East Anglia ONE North and East Anglia TWO Offshore Windfarms

Applicants' Comments East Suffolk Council's Deadline 11 Submissions

Applicant: East Anglia TWO and East Anglia ONE North Limited
Document Reference: ExA.AS-12.D.12.V1
SPR Reference: EA1N_EA2-DWF-ENV-REP-IBR-001112

Date: 28th June 2021
Revision: Version 1
Author: Royal HaskoningDHV

Drg No	EA1N-EA2-DEV-DRG-IBR-001281
Rev	3
Date	04/03/21
Figure	1
Coordinate System:	BNG
Datum:	OSGB36

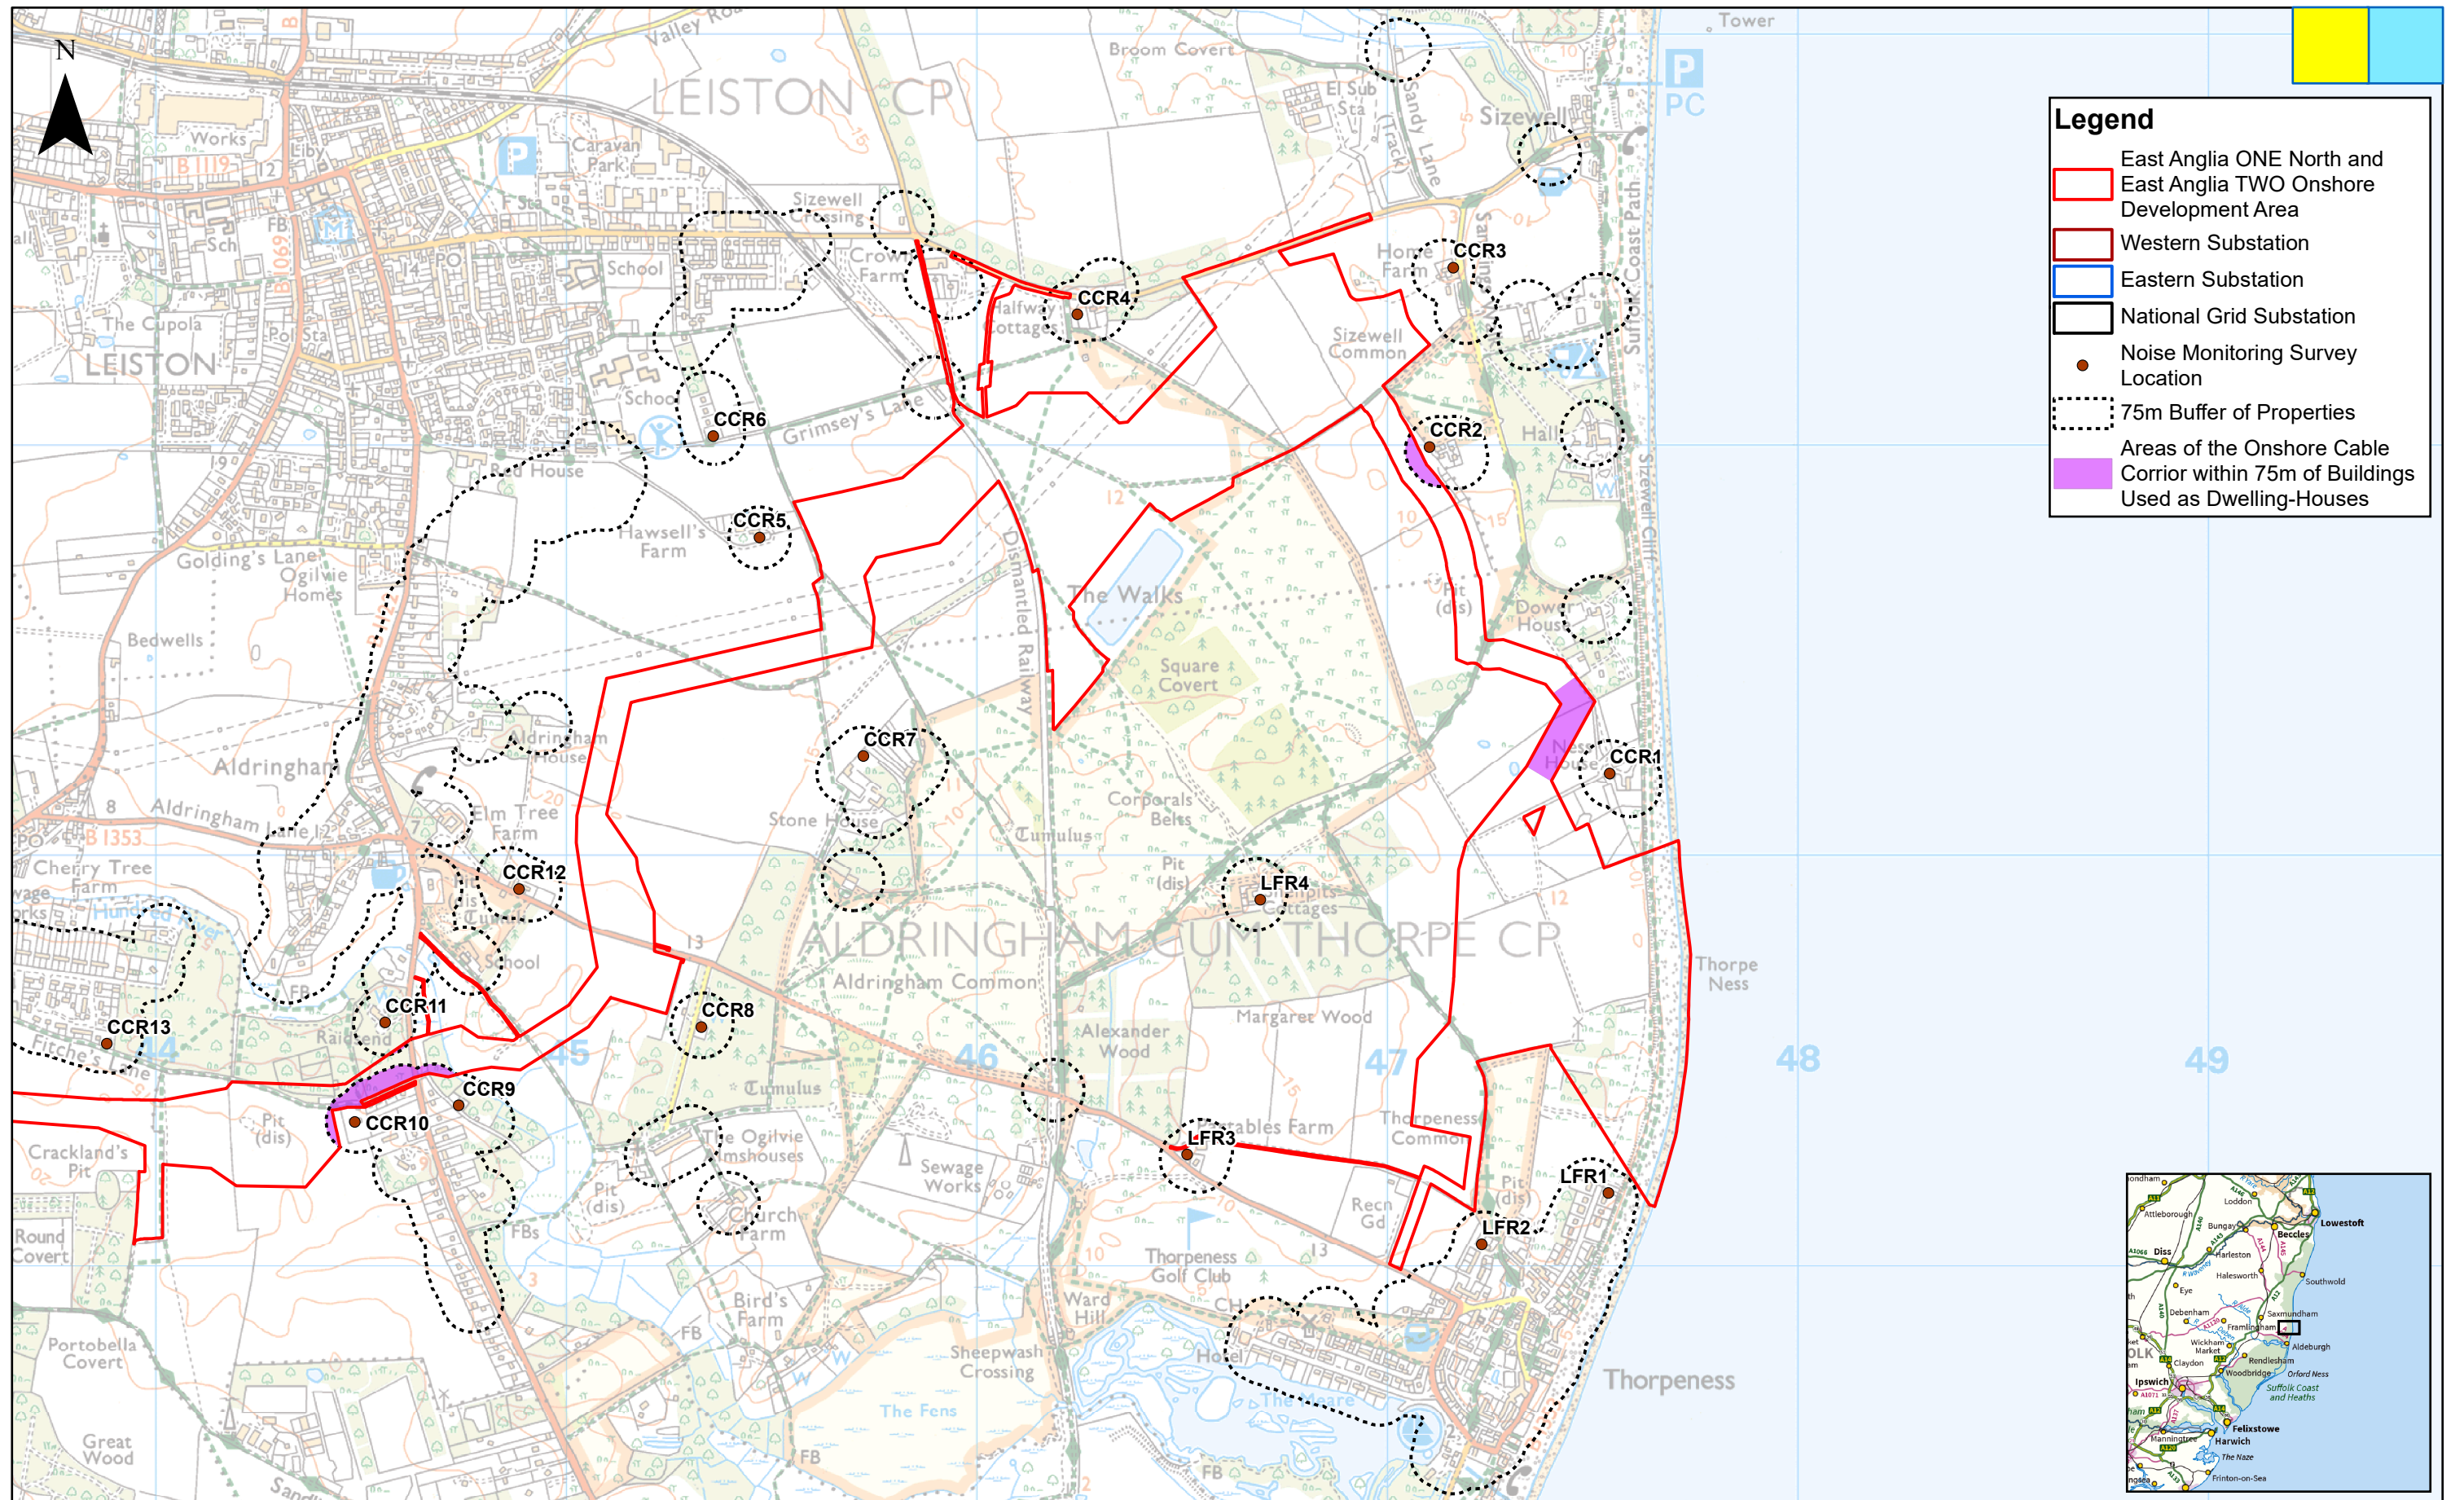
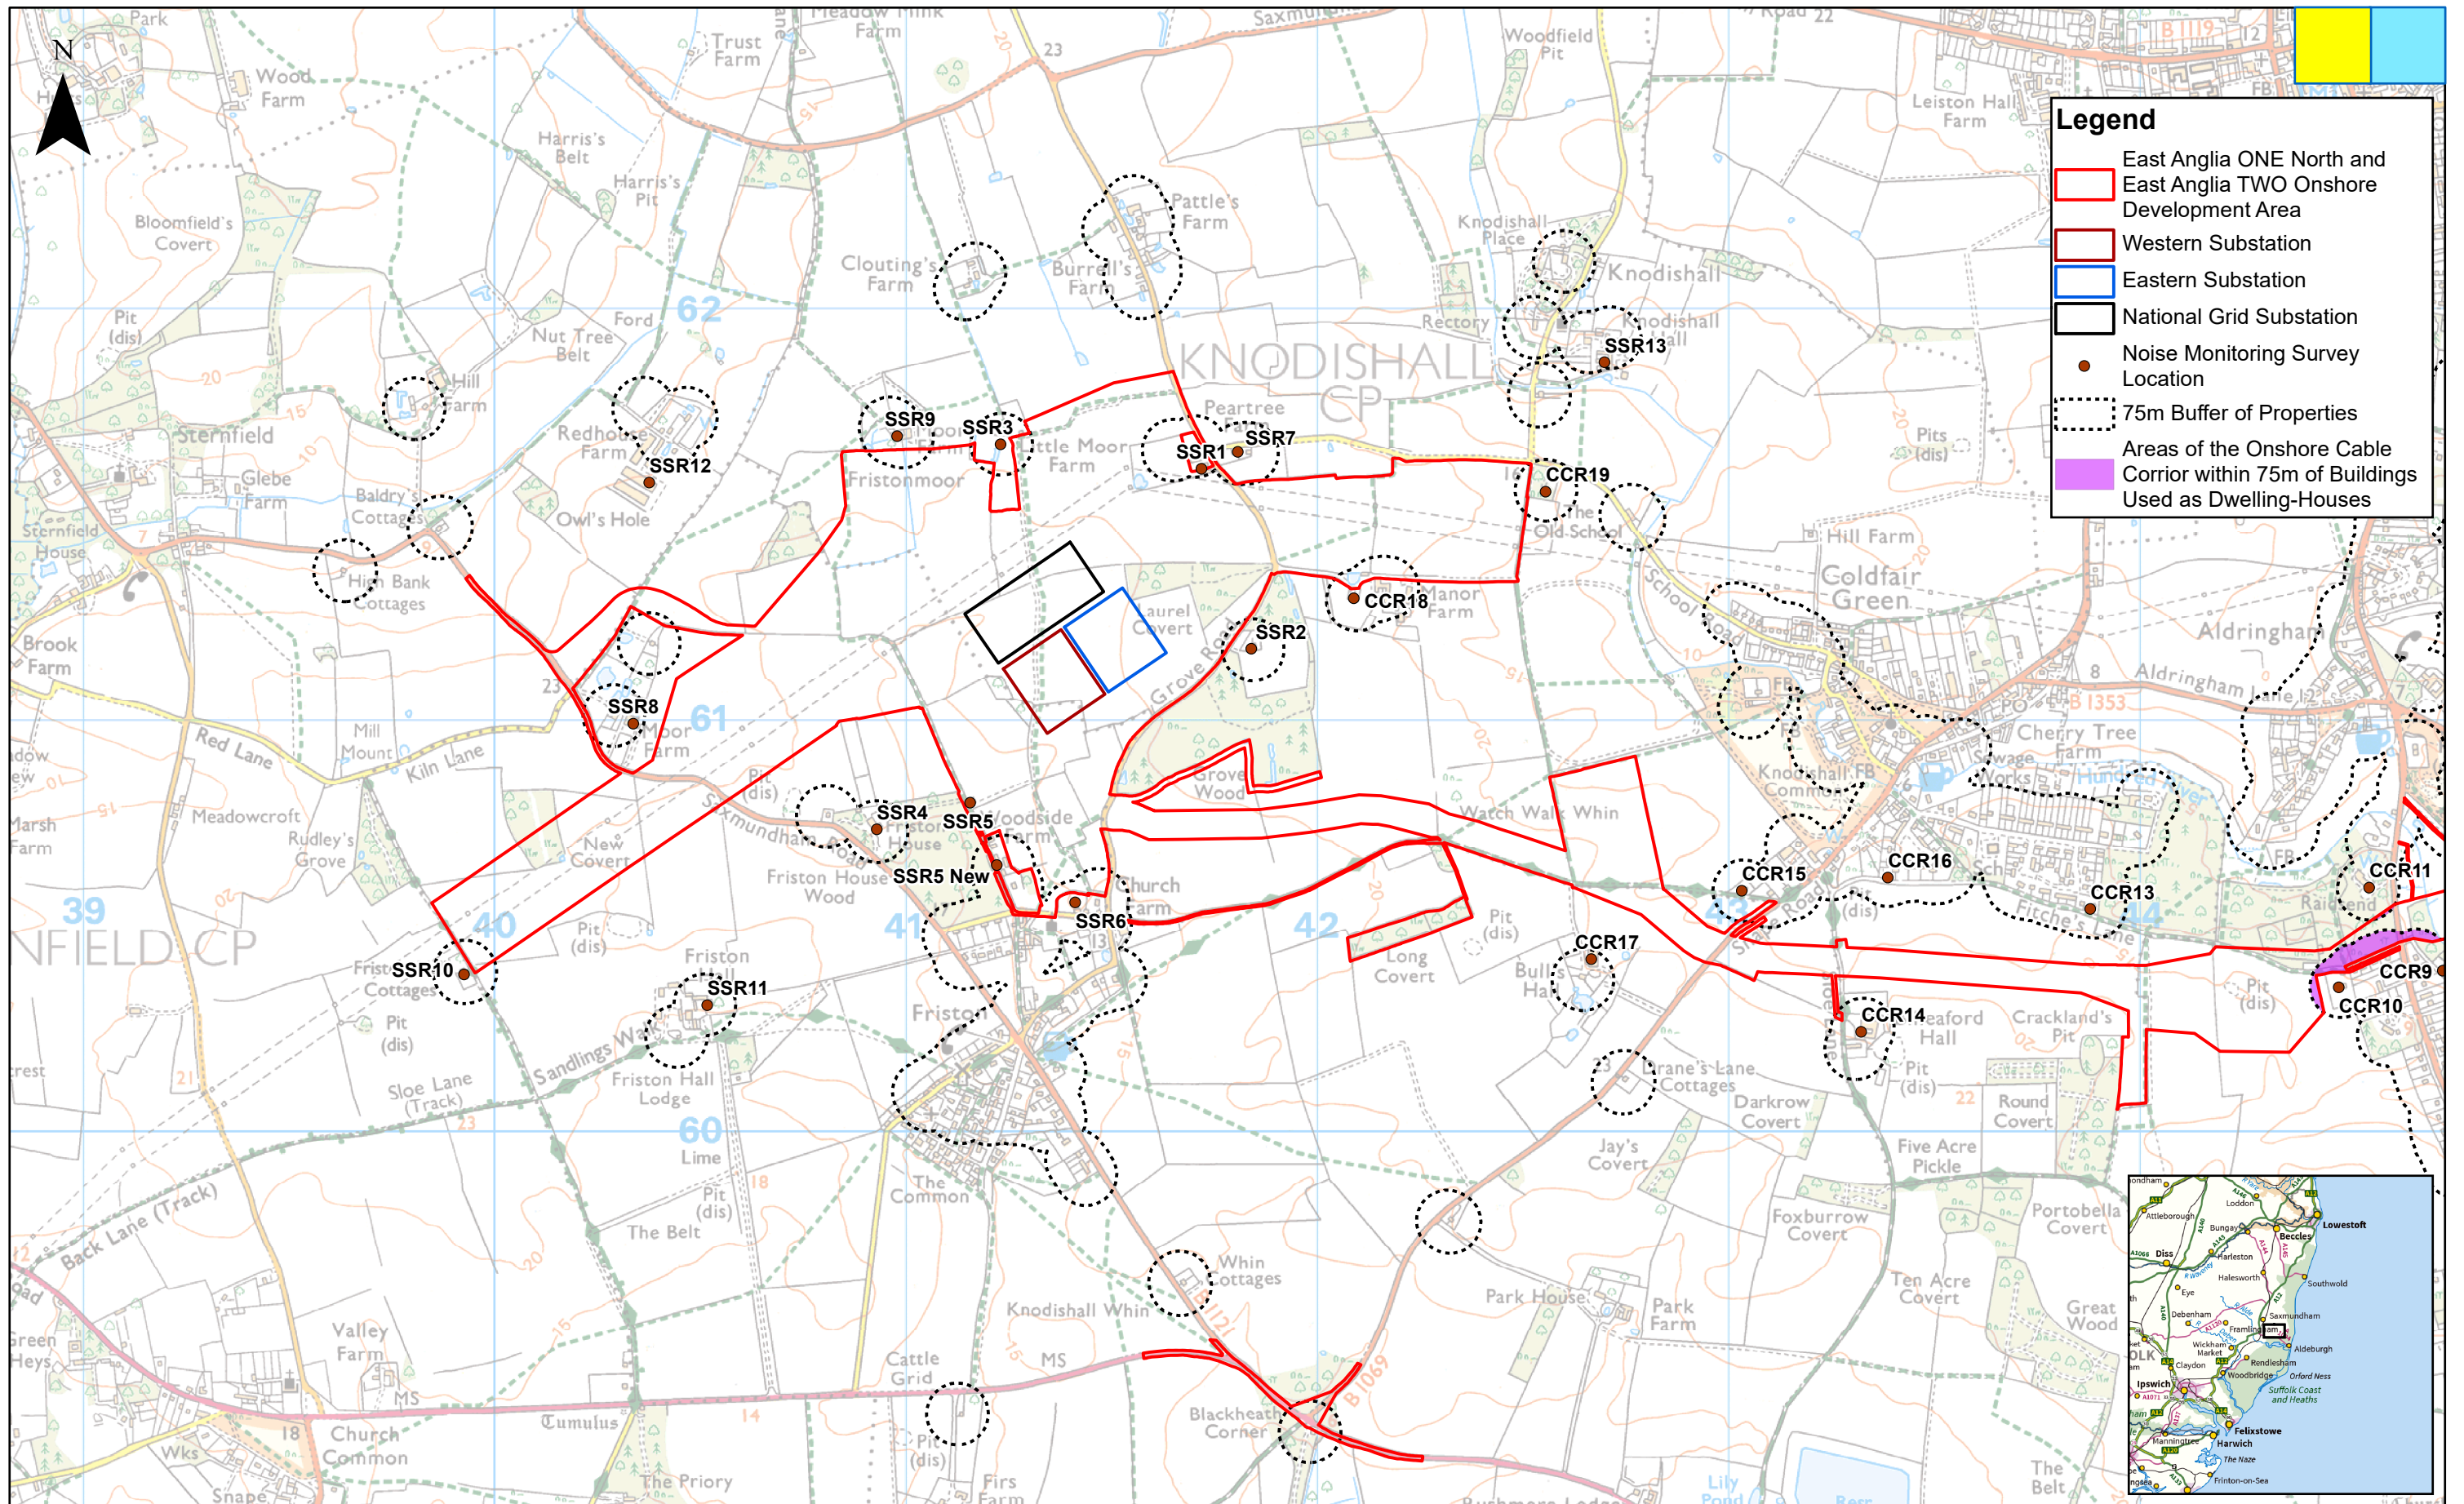
ID	ESC Comment	Applicants' Comments
53	<p>Section 10.1.6 Measures Specific to Non-Road Mobile Machinery (NRMM), paragraphs 145-146</p> <p>The text within the third bullet point within this paragraph refers to the 'Figure 1, Appendix 1' a minor correction is necessary as the text should refer to 'Figure 1, Appendix 2'. The text could also be a little clearer regarding where non-compliant NRMM will be deployed. Although alterations to the text have been suggested below to add clarity, this change although desirable is not considered essential.</p> <p><i>"Use of NRMM which is not compliant with Stage IV emissions standards or later will be restricted to areas outside the 100 metre Buffer of Properties and away from designated habitat sites Potential Sensitive Receptors and Areas Subject to Additional Construction Phase Controls shown in Figure 1, Appendix 2 where practicable."</i></p>	<p>See response at ID50 relating to the location of Figure 1.</p> <p>An updated Outline CoCP has been submitted at Deadline 12 (document reference 8.1).</p>
